October 20, 2005

RE: Harnett County Land Use Application # 05-5-12654

Based on the criteria set out in Title 15A, Subchapter 18A, of the North Carolina Administrative Code, Rules .1950, the evaluation indicated that the site is **UNSUITABLE** for the addition requested. Therefore, your request for an existing tank is **DENIED**. The site is denied based on the following:

Site Plan
The Harm
hereby at

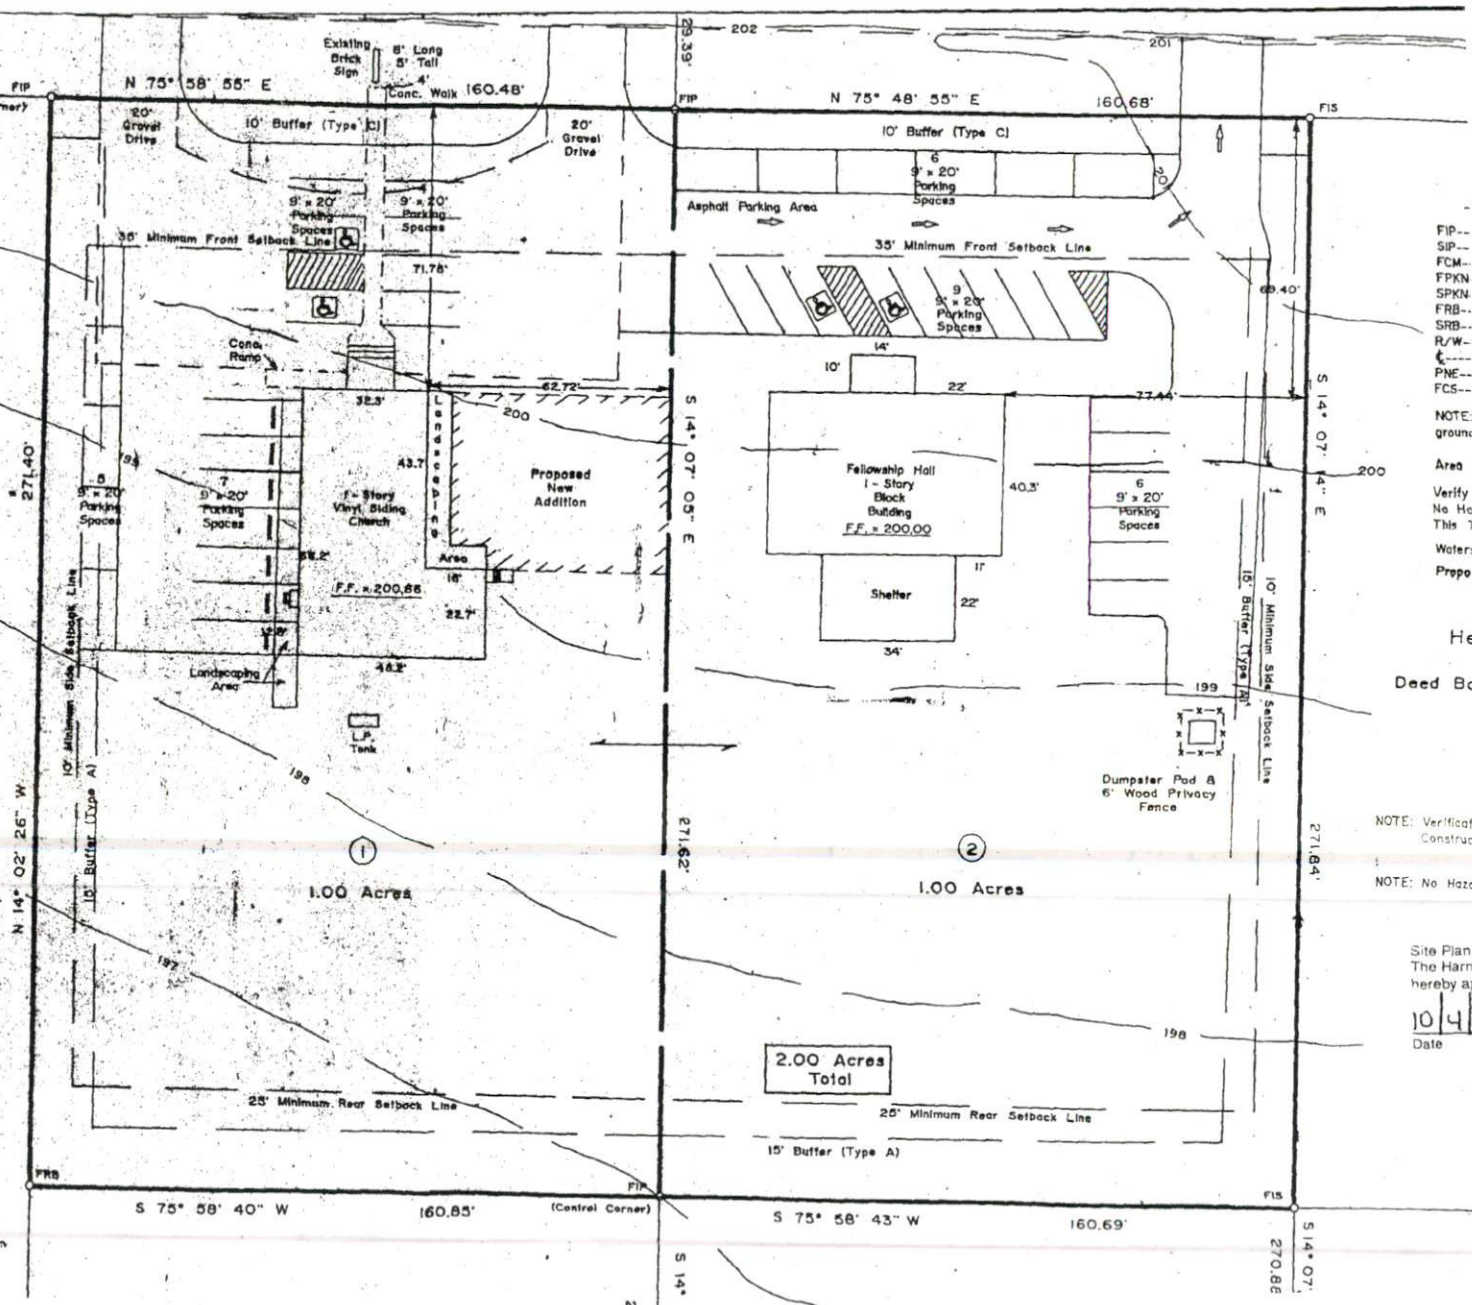
X **15A NCAC 18A.1950 (10) – Any building to be 5' from drain line.**
